Overwhelming Grounds for Rejecting Requested Modification 2 for Proposed Capital II Wind Farm

Dr Michael Crawford October 21, 2014

The request to modify the Capital II wind farm by increasing rotor blade length should be rejected on at least three grounds: noise impact; visual impact; and impact on avifauna. The proposal is misleading and/or totally inadequate in its advice about the effect of the proposal on each of those aspects.

FIGURE 5
CAPITAL II WIND FARM
PREFERRED LAYOUT & FLORA SURVEY

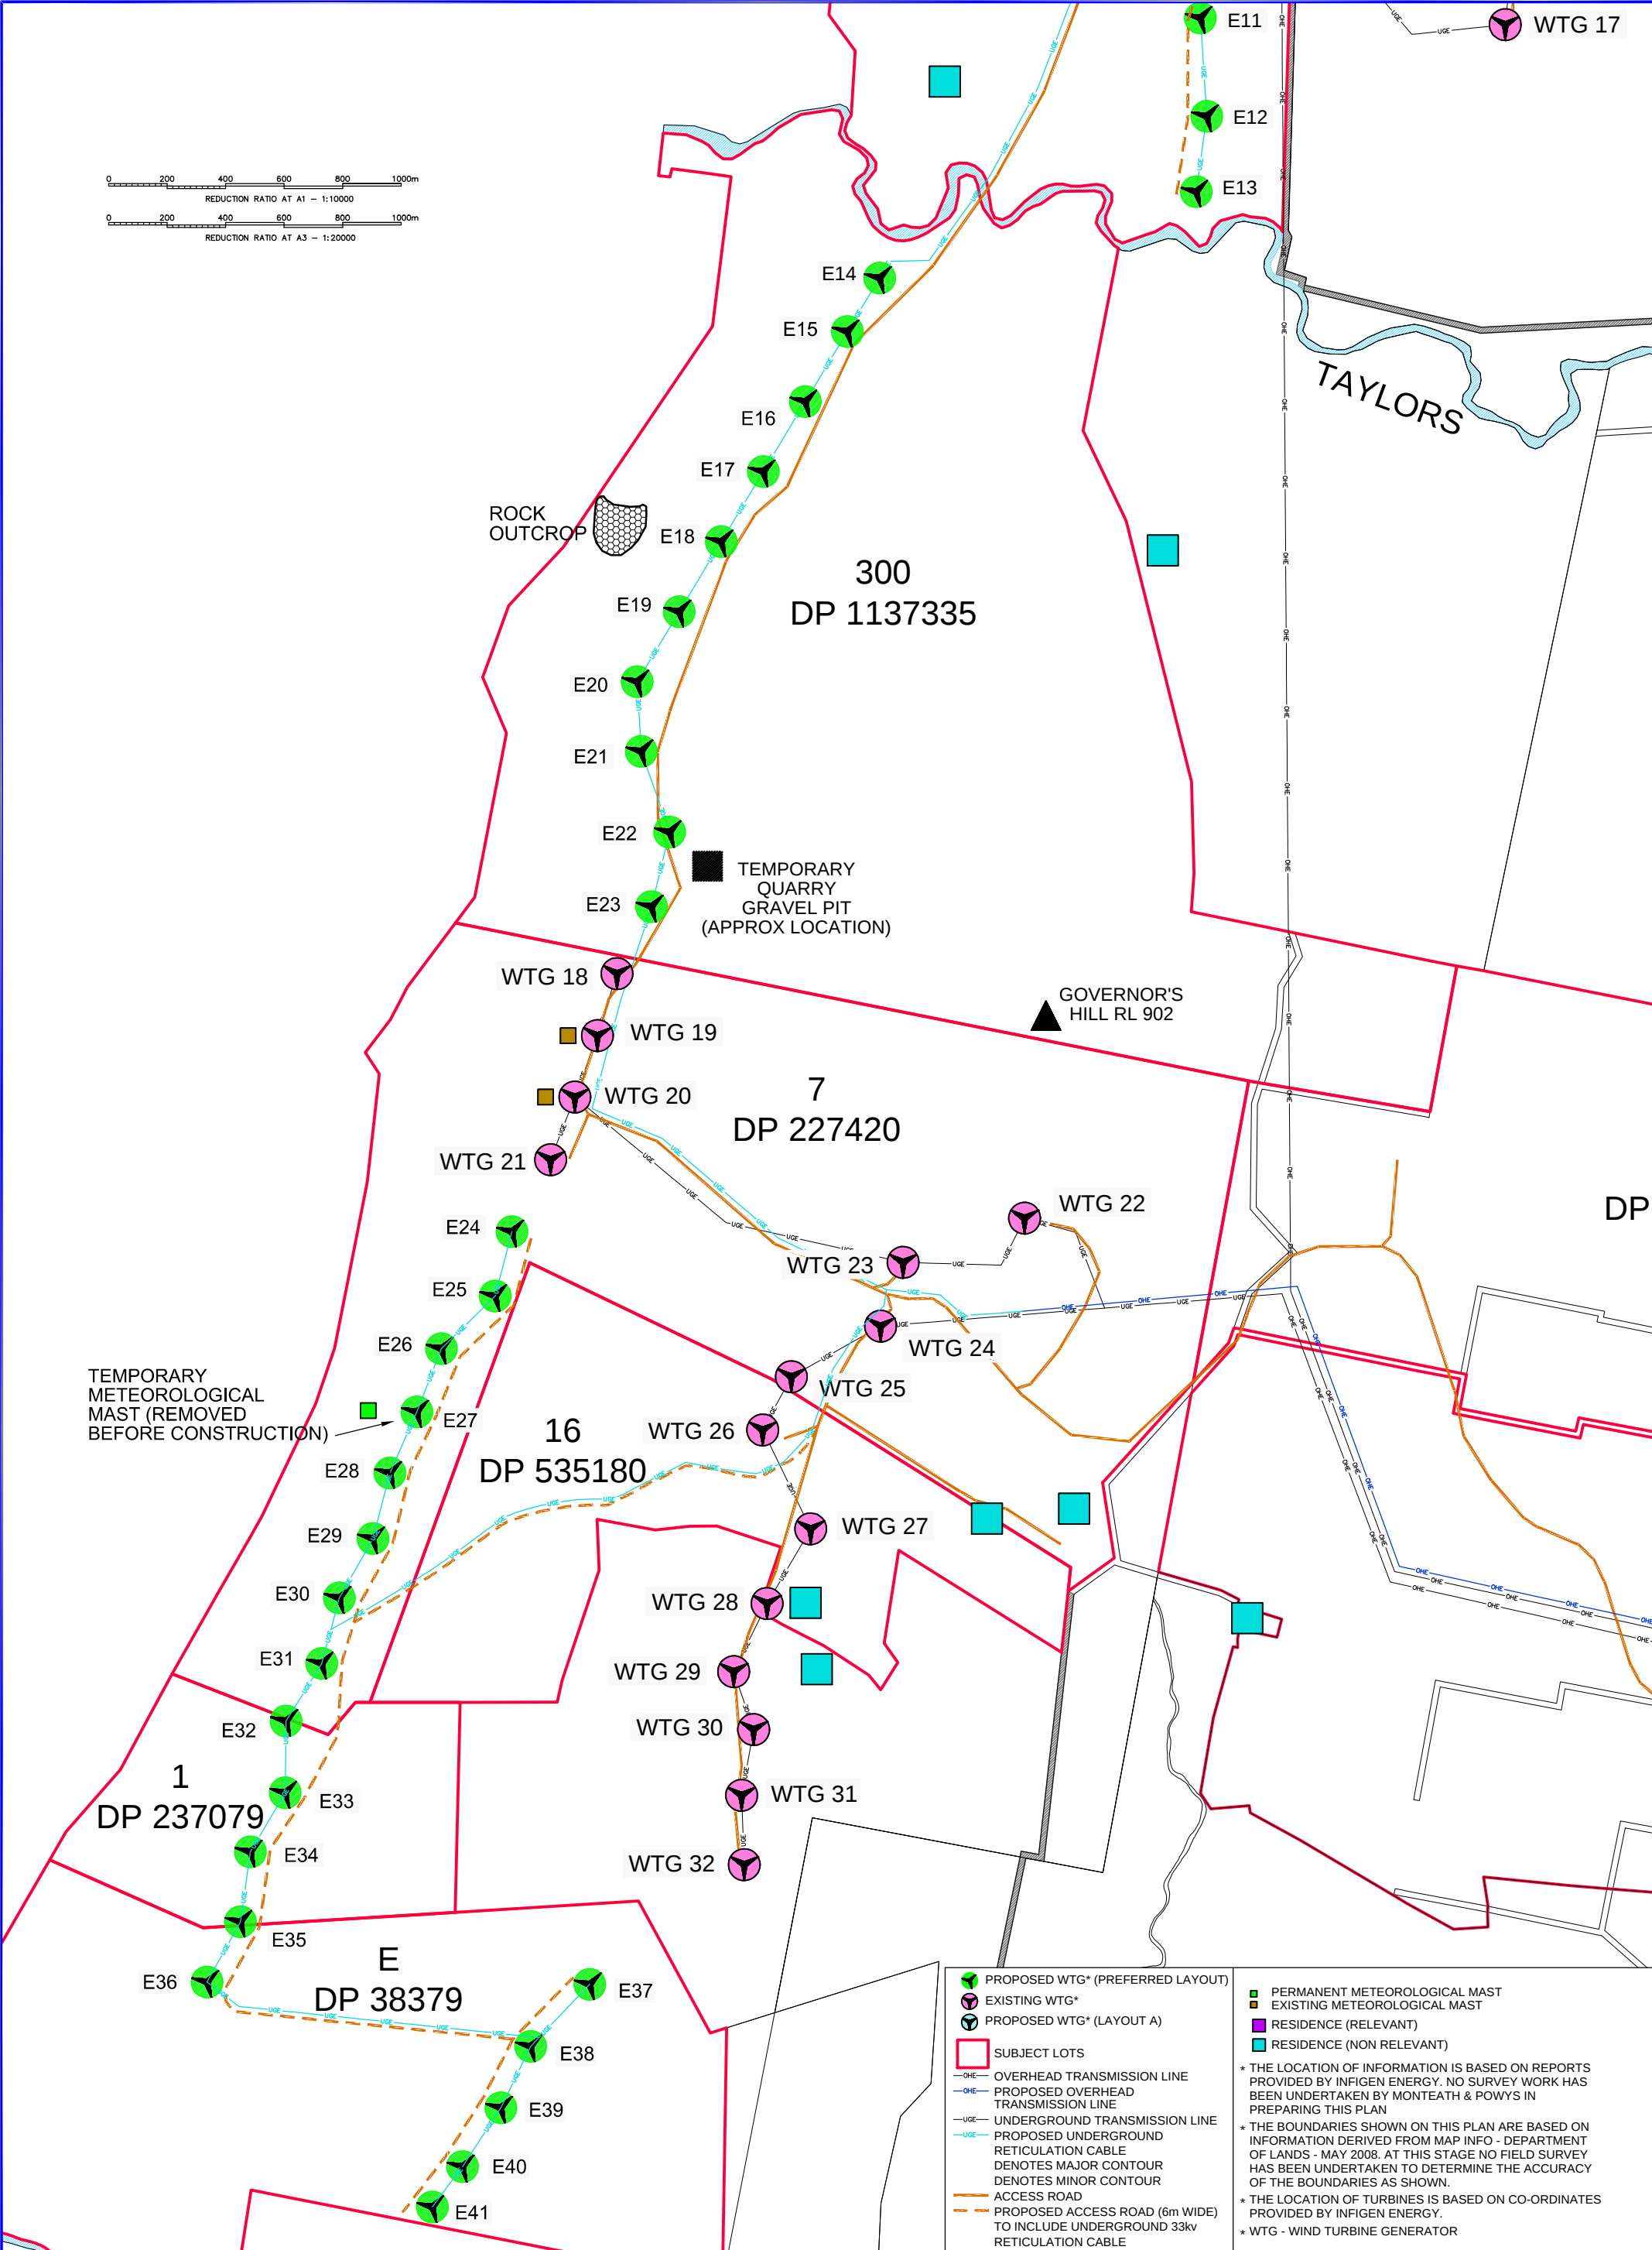
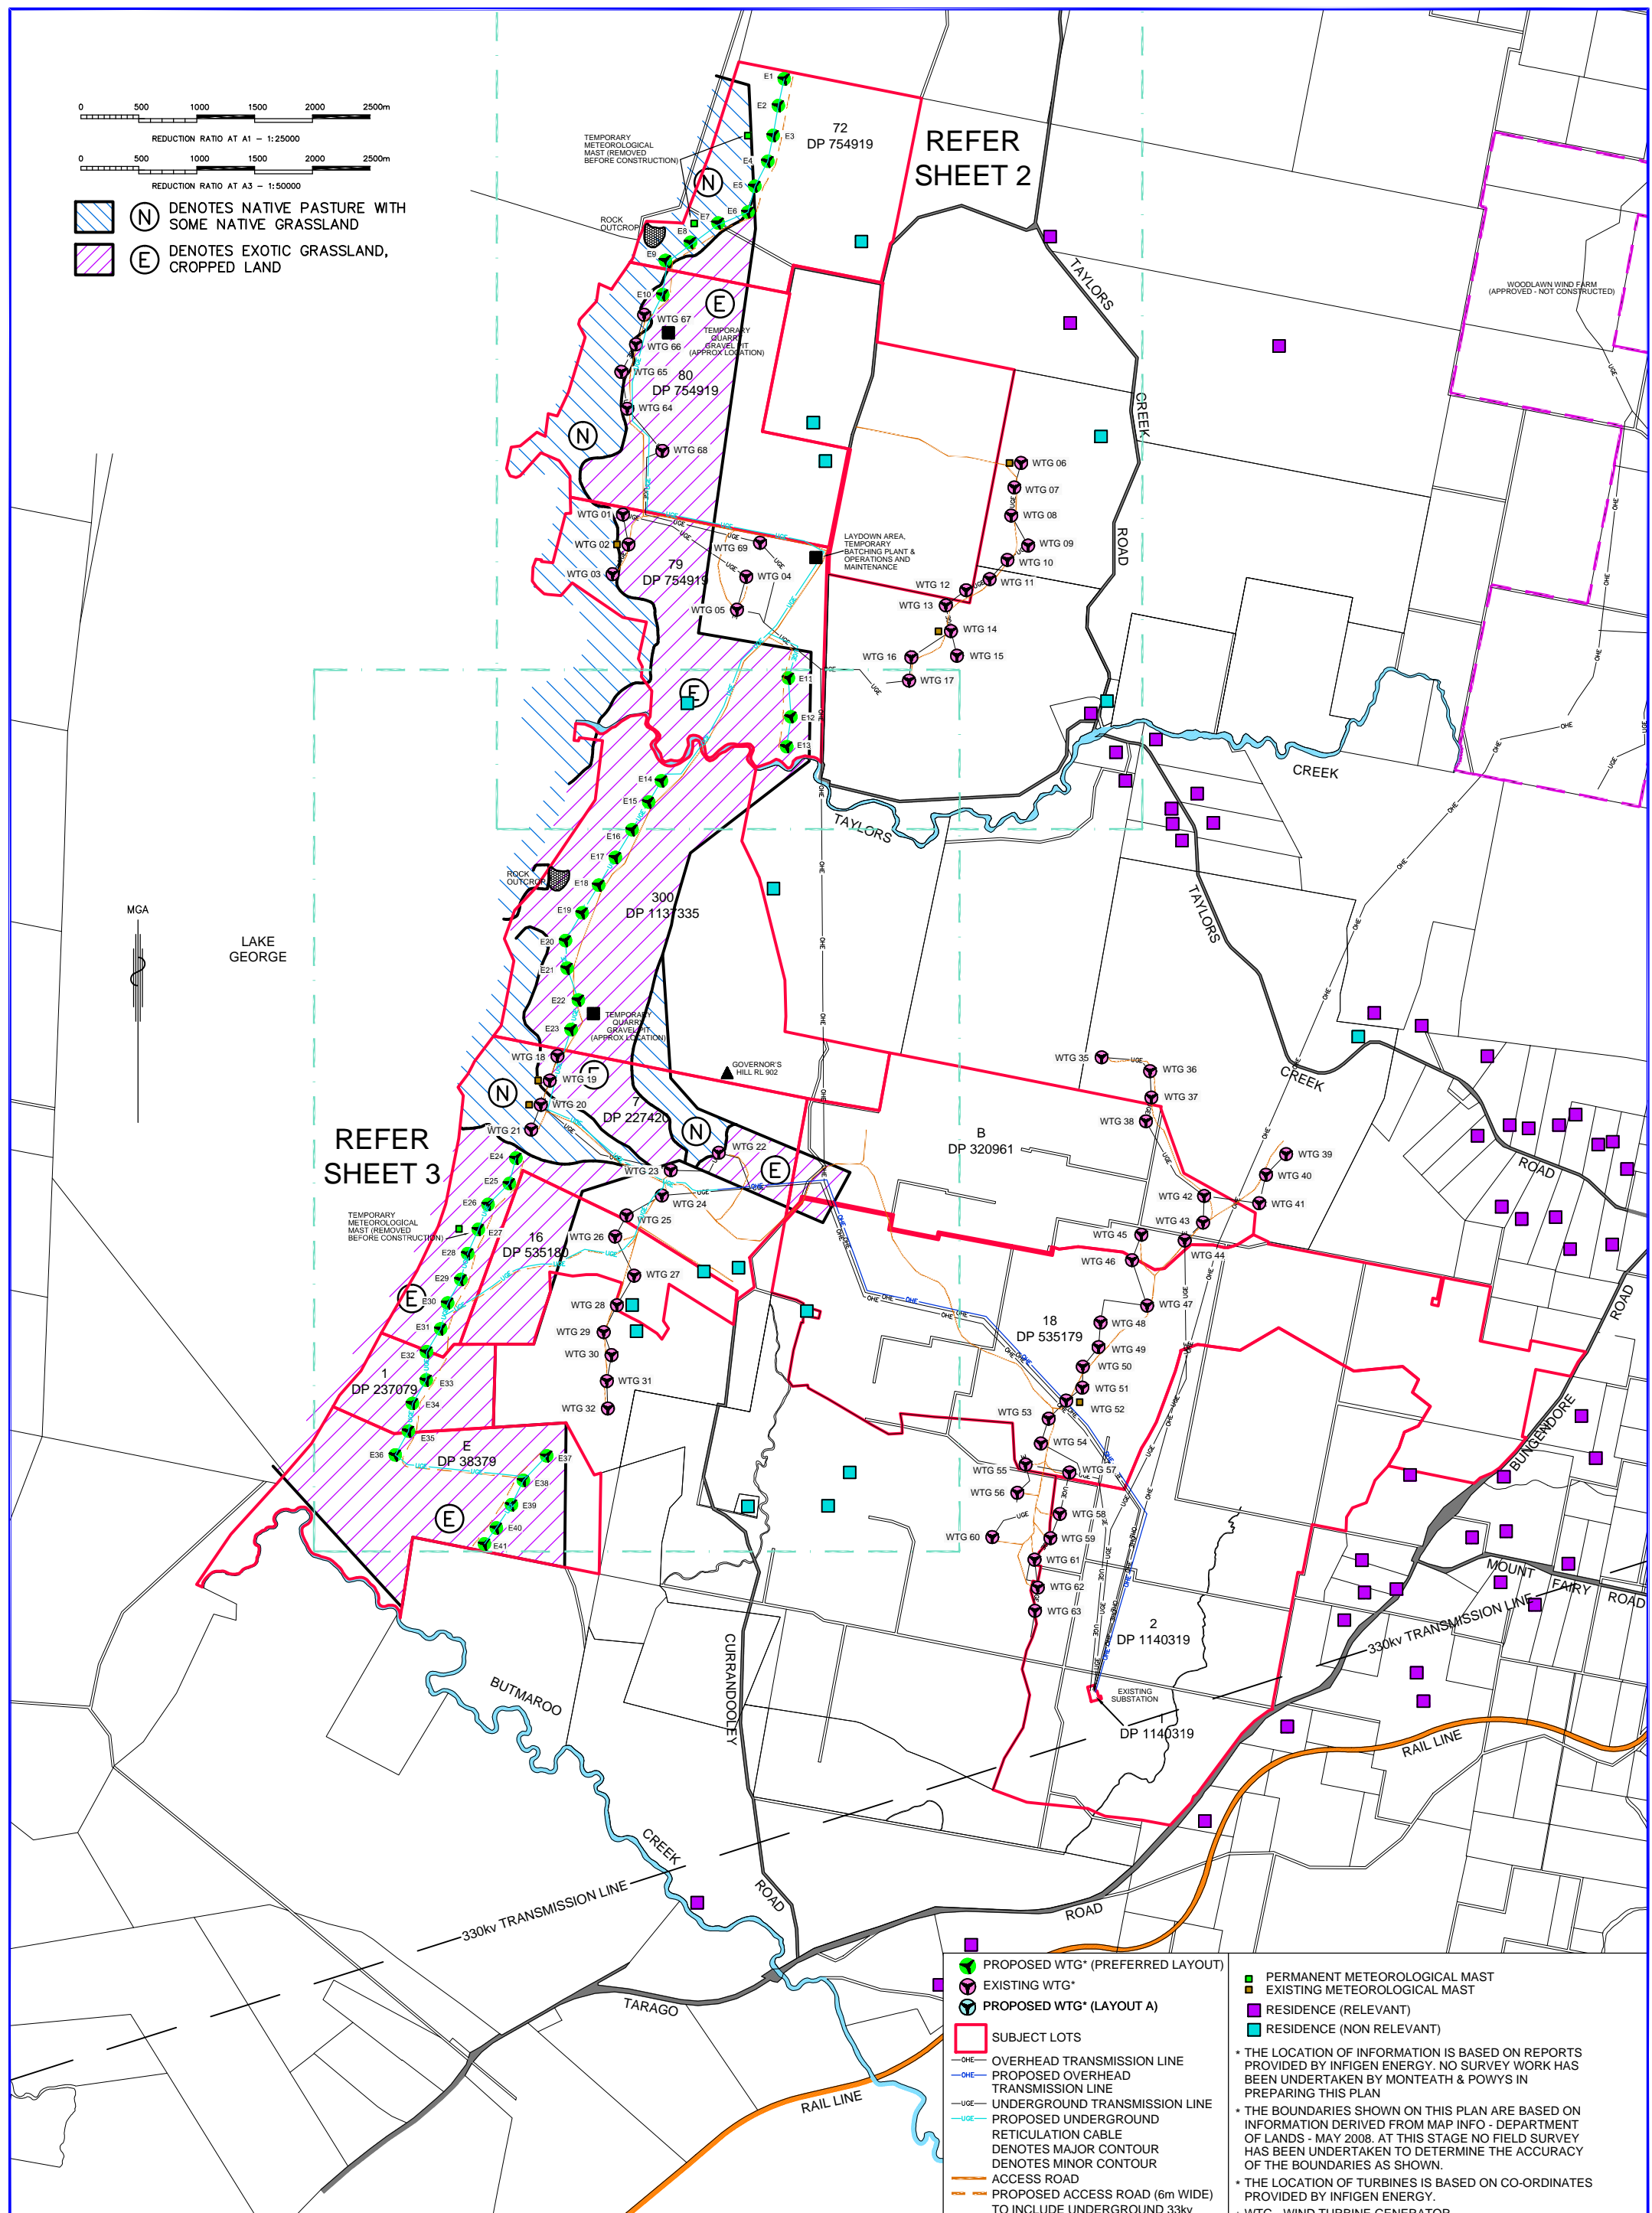
From the turbine map published¹⁵ with approval for Modification 1 of the Capital II Wind Farm, it appears that the majority of the new turbines will be only several hundred metres apart, in many cases perhaps as little as 200 metres apart. That small interturbine separation applies not just to the turbines added as part of Capital II but also to the distance between some of the new turbines and ones already in place.

Using the SEDA rule noted above, the minimum interturbine distance for WTGs with 114 metre rotor diameters would be 570 metres. SEDA actually says:

"On very directional sites the 'abreast spacing' can be decreased by around 15 per $\mbox{cent}^{\rm *16}$

Allowing for that factor would reduce the appropriate minimum spacing for the Capital II turbines to 485 metres, if they have a rotor diameter of 114 metres as currently approved. On that basis, the actual interturbine distance proposed for Capital II appears to be between 41% and 52% of the spacing recommended by SEDA.

If the rotor diameter is increased to 126 metres, then the minimum spacing would be 535 metres. In that case, if the turbines stay as shown in the Modification 1 submission, then the actual interturbine distance proposed for Capital II appears to be between 37% and 47% of the spacing recommended by SEDA.

In light of the SEDA recommendations it is astounding the original application was approved. Given that it was, unless Infigen is proposing to reduce the number of turbines, and the modification request has not mentioned it, then the interturbine spacing will become substantially worse compared to SEDA's recommendations, dropping from the range 41%-52% down to 37%-47%.

In addition, there is no comment on the fact that since Capital II is largely a long line of WTGs abreast of one another, the increased rotor diameter would significantly reduce the unimpeded gap between WTGs. Along most of a distance of about 15 kms, approximately half or more of the air space would be occupied by rotating blades, and the proposal increases the area so occupied by more than 10% and correspondingly reduces the area safe for avifauna by a similar amount. This is surely relevant to any assessment of avifauna impact.

Figure 9: Zone of Visual Influence (based on topography), Overall Catchment.

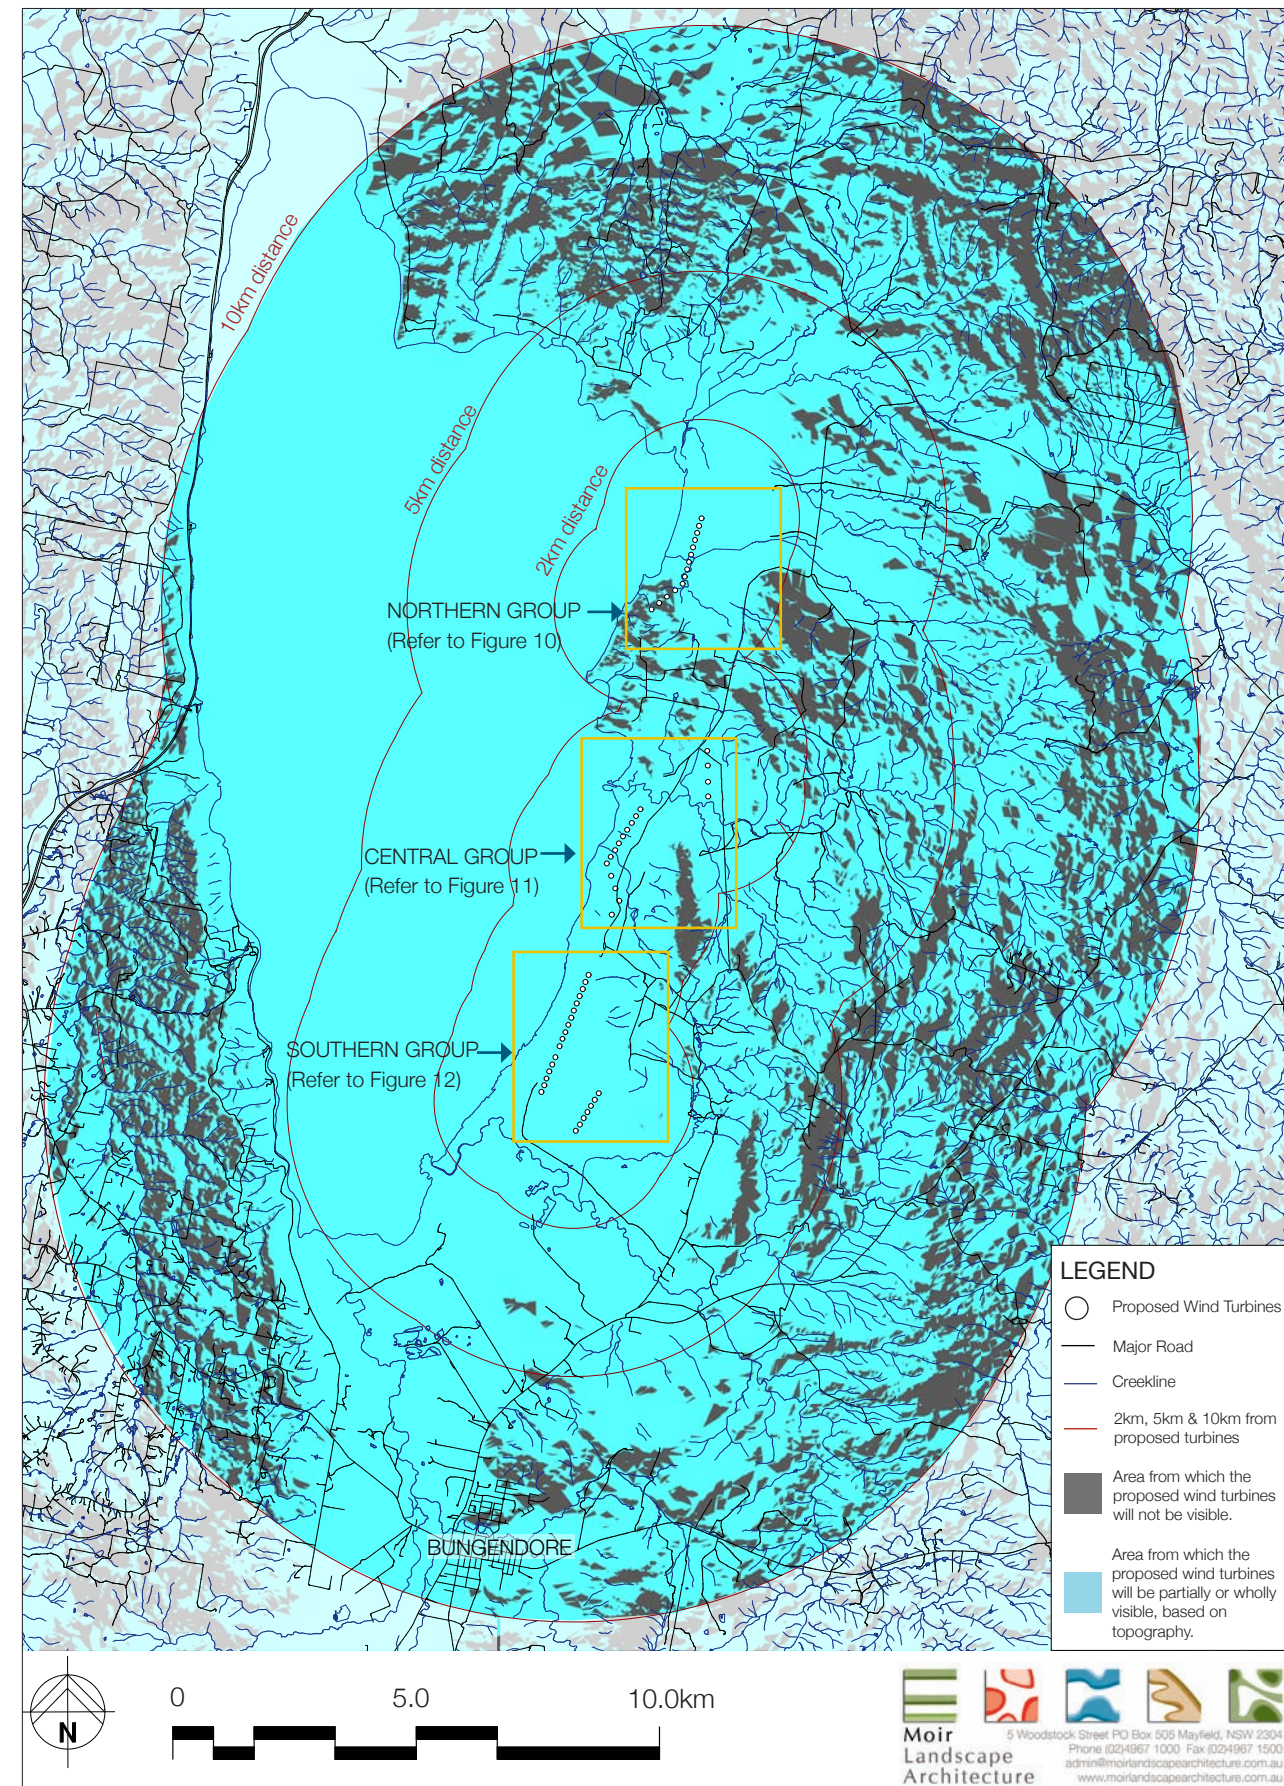
The best practice Zone of Visual Influence (ZVI) recommended by Scottish National Heritage is dependent on the tip height of wind turbines. The ZVI is the area within which there may be some visual impact from the wind turbines and for which the impact should be assessed. For WTGs over 150 metres to tip, the appropriate ZVI is 45 kms ¹⁸. It should be noted that the best practice ZVI is based on tip height of turbines, not tower height.

The proposed modification should not be accepted without a well conducted visual impact assessment ¹⁹ that:

• uses a ZVI reasonably consistent with the best practice ZVI identified by Scottish National Heritage (which would certainly include Collector, Tarago and Bungendore);
